The Member-Secretary,  
Chennai Metropolitan  
Development Authority,  
No.8, Gandhi Irwin Road,  
CHENNAI -600 008

Letter No. B2/3324/2000

Dated: 11.5.2000.

Sub: CMDA - Area plans unit - Planning  
Permission - Proposed construction of  
Ground + 3 floors Residential building with  
12 dwelling units at T.S.No.5837/1, Block  
No.131 of T.Nagar in Door No.30, Sadullah  
Street, T.Nagar, Chennai-17 - D.C. advice  
sent - Reg.

SITE / GROUND FLOOR PLAN

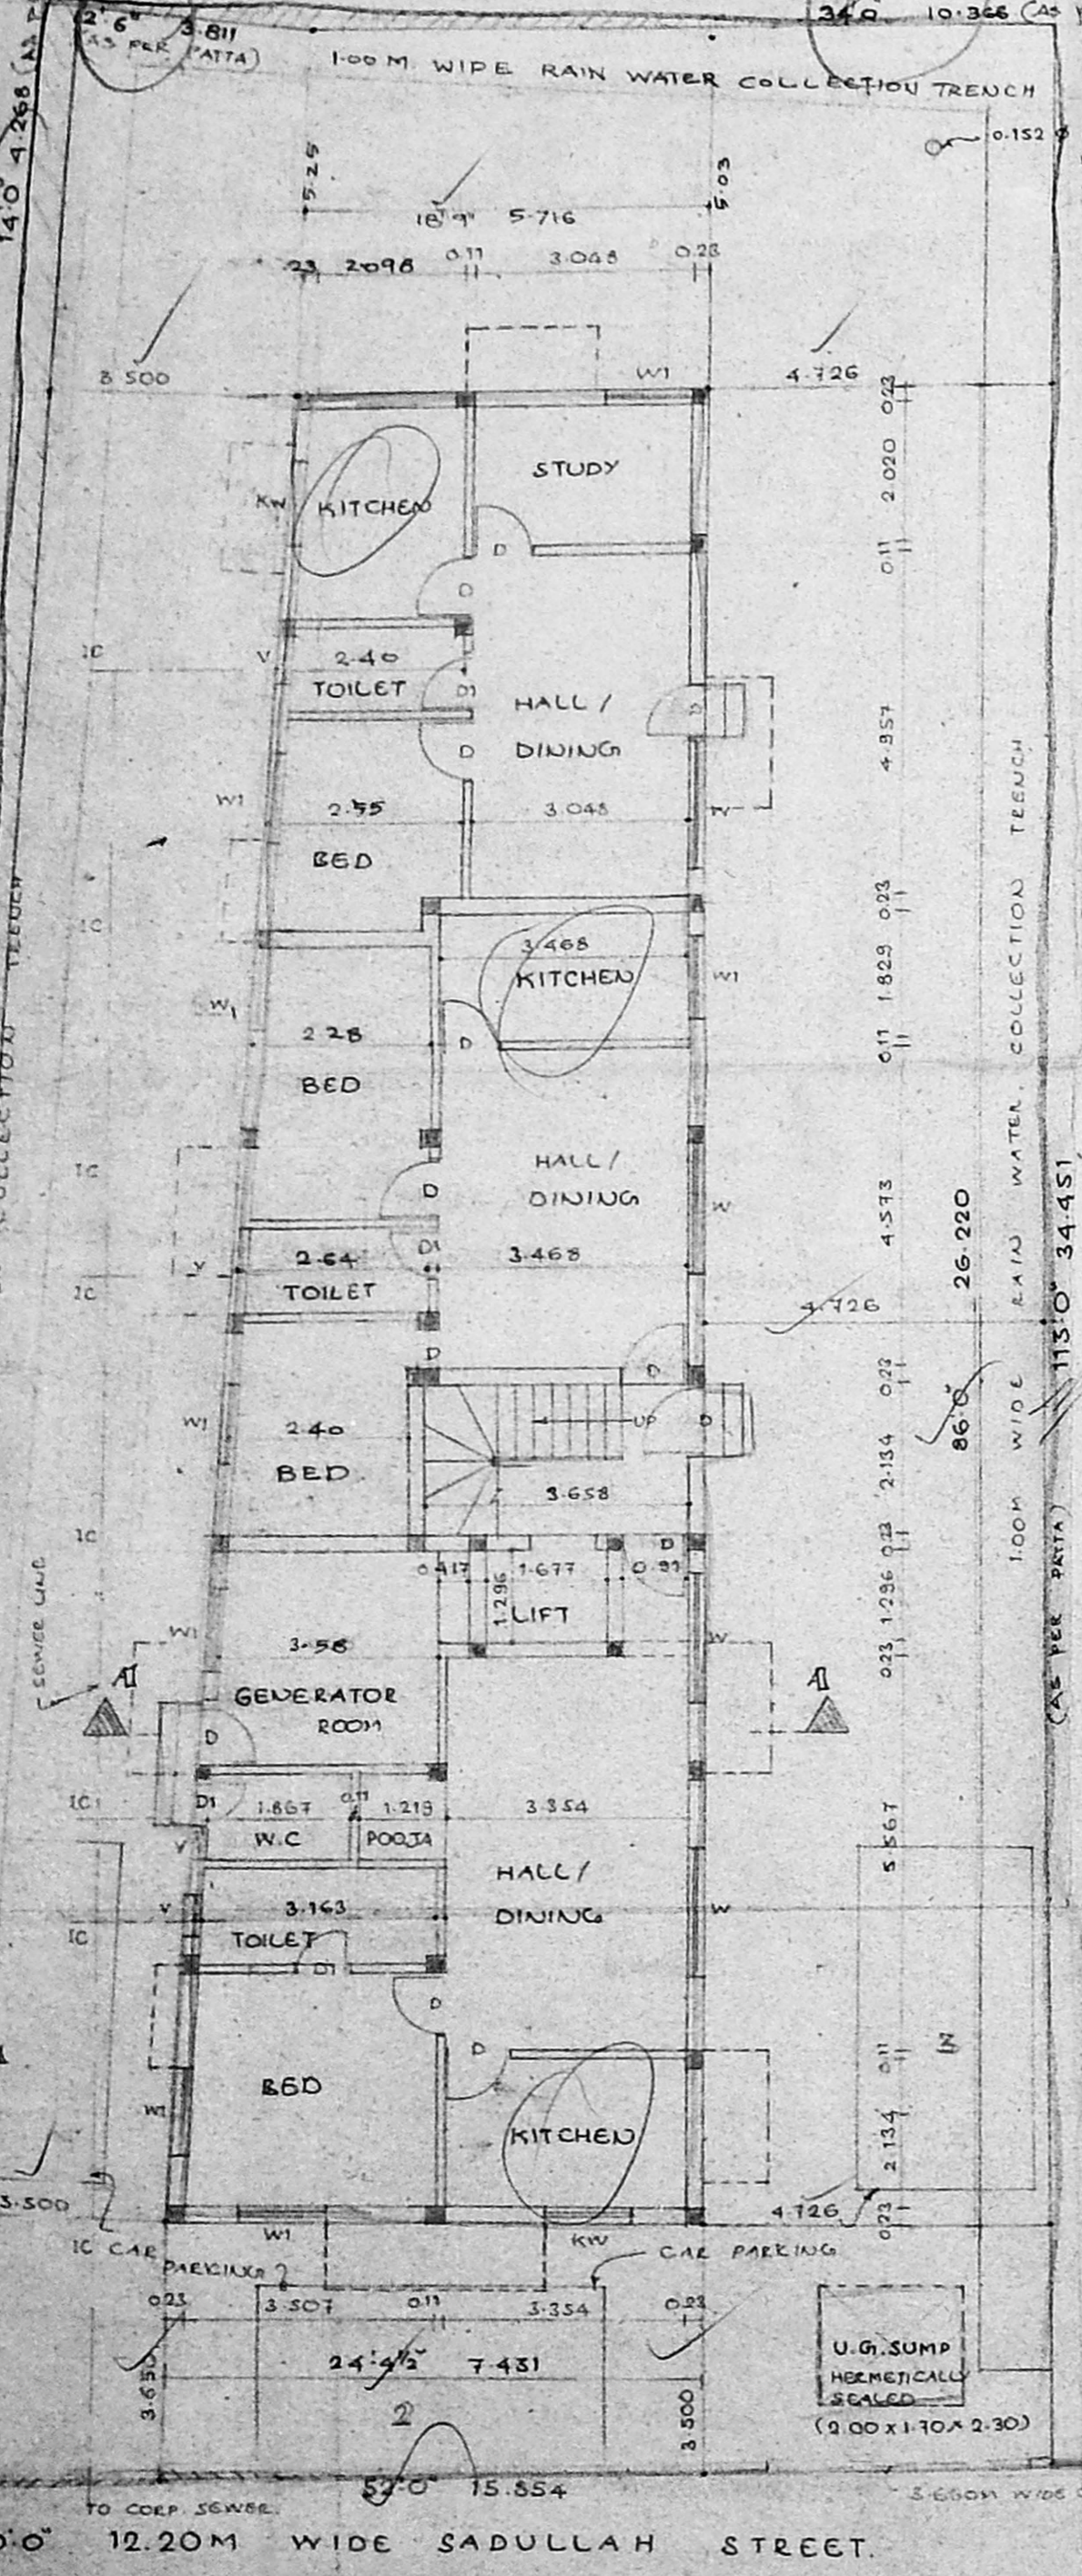
- 1) Revised plan showing the site boundary measurements, as per Patta and, as well as, ~~as per as on site condition~~ and marking the difference by hatching and ~~to provided~~ required setback spaces from the minimum dimension line.
- 2) Revised plan mentioning the revenue village name in which the site under reference lies.
